Letter No. B1/2171/2003

Sub: CMDA - Area Plans Unit - Planning permission  
proposed construction of Ground Floor +  
Mezanine floor + 2 floor residential building with  
4 dwelling units at Plot No. 9, New No. 7,  
Door No. 7, State Bank Officer's Colony 1st  
street, T.S.No. 5/5, Block No. 15, Arumbakkam  
Chennai - Remittance of Development charges and  
other charges - reg

SECOND FLOOR PLAN

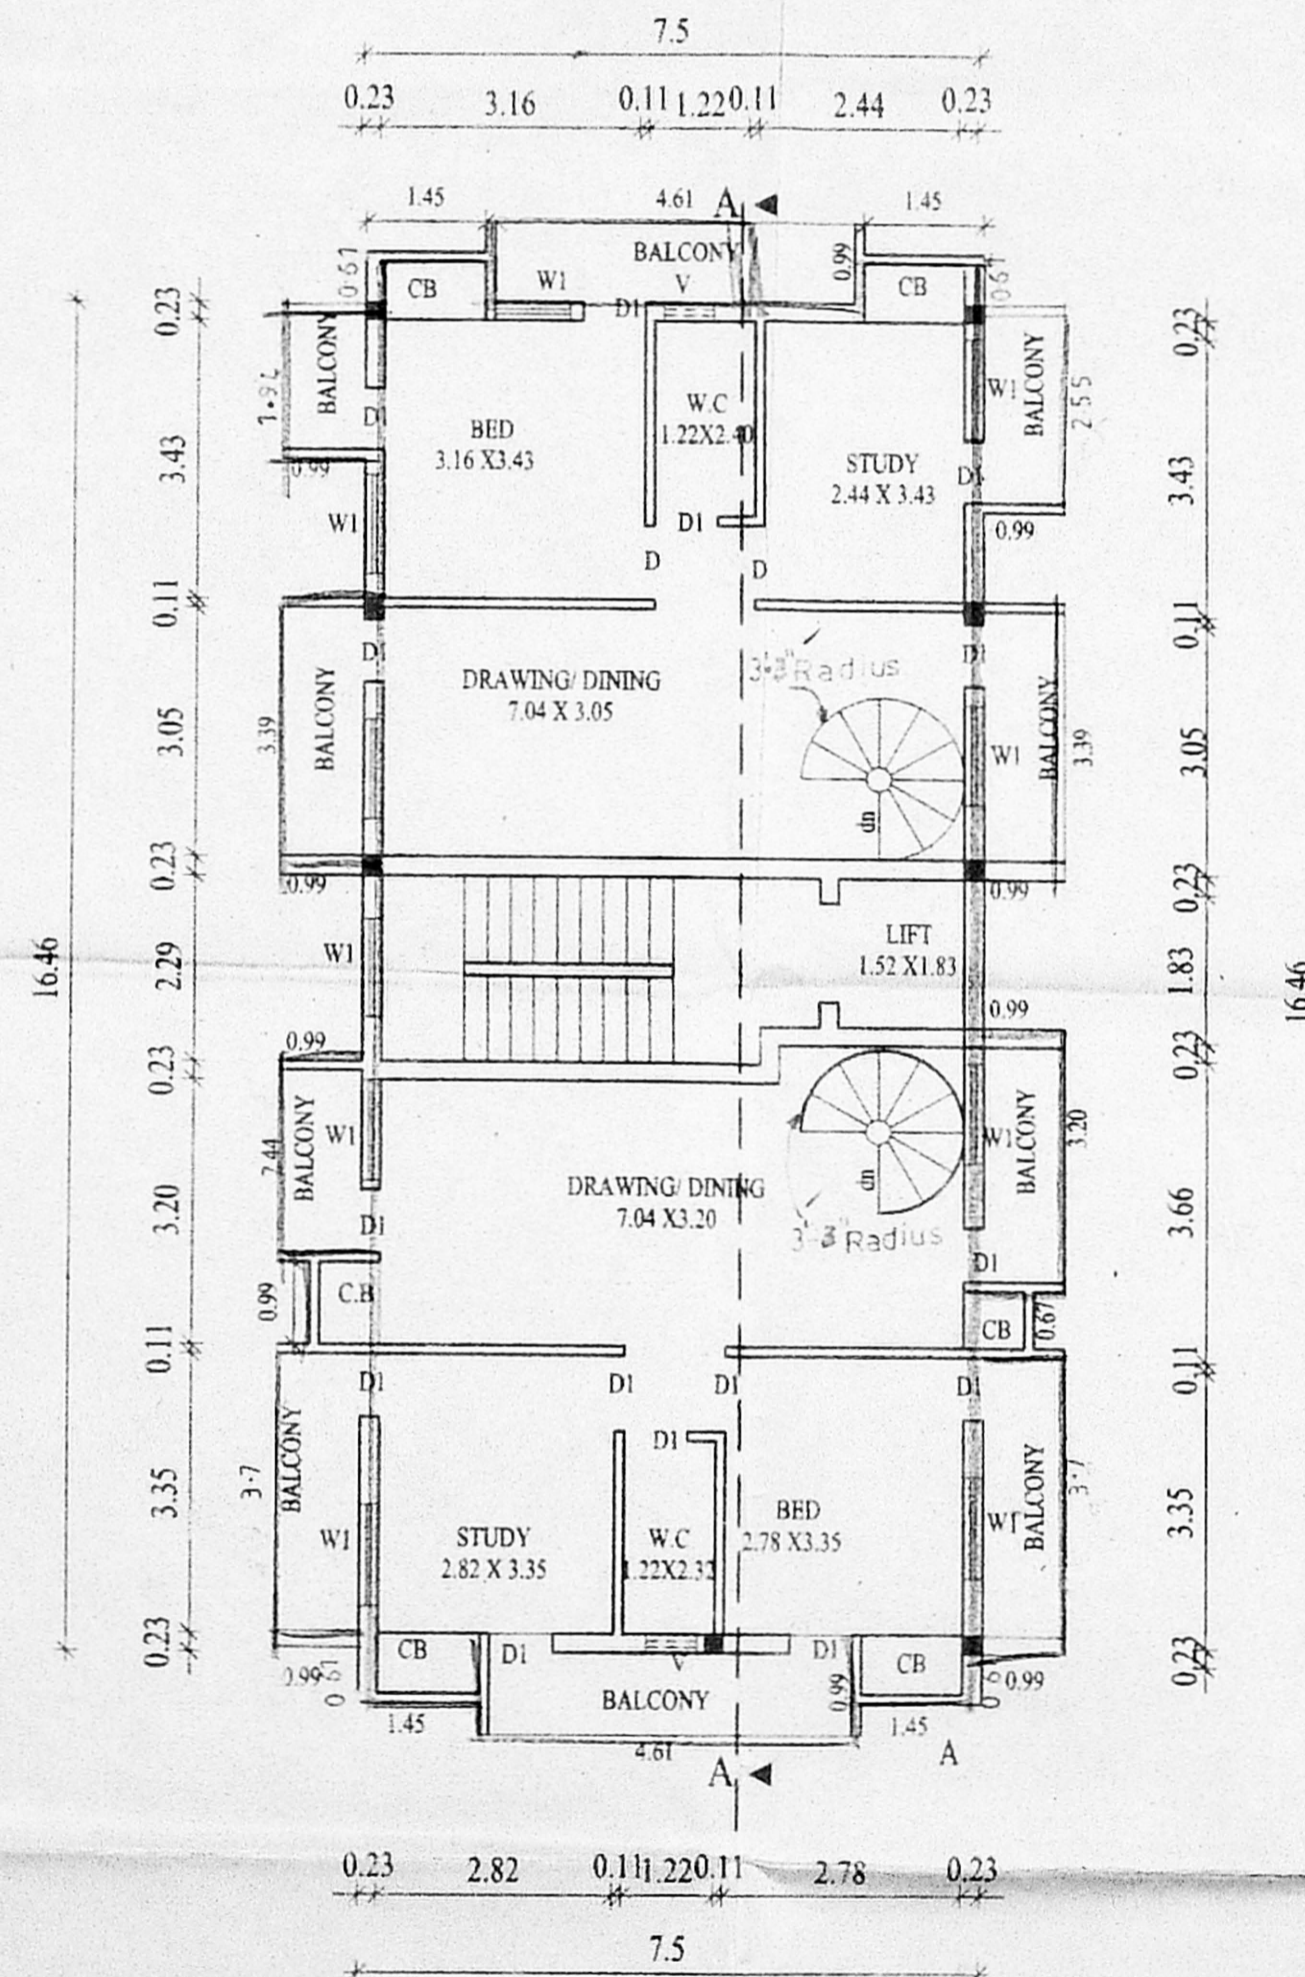
- 1) Width and depth shall be indicated for the pebble trench
- ii) In the area statement, floor areas needs correction.
- iii) Radius 3'3" for the circular staircase shall be indicated in all the floors correctly.
- iv) Lift entry in Mazzanine floor shall be closed as it is not accessible.
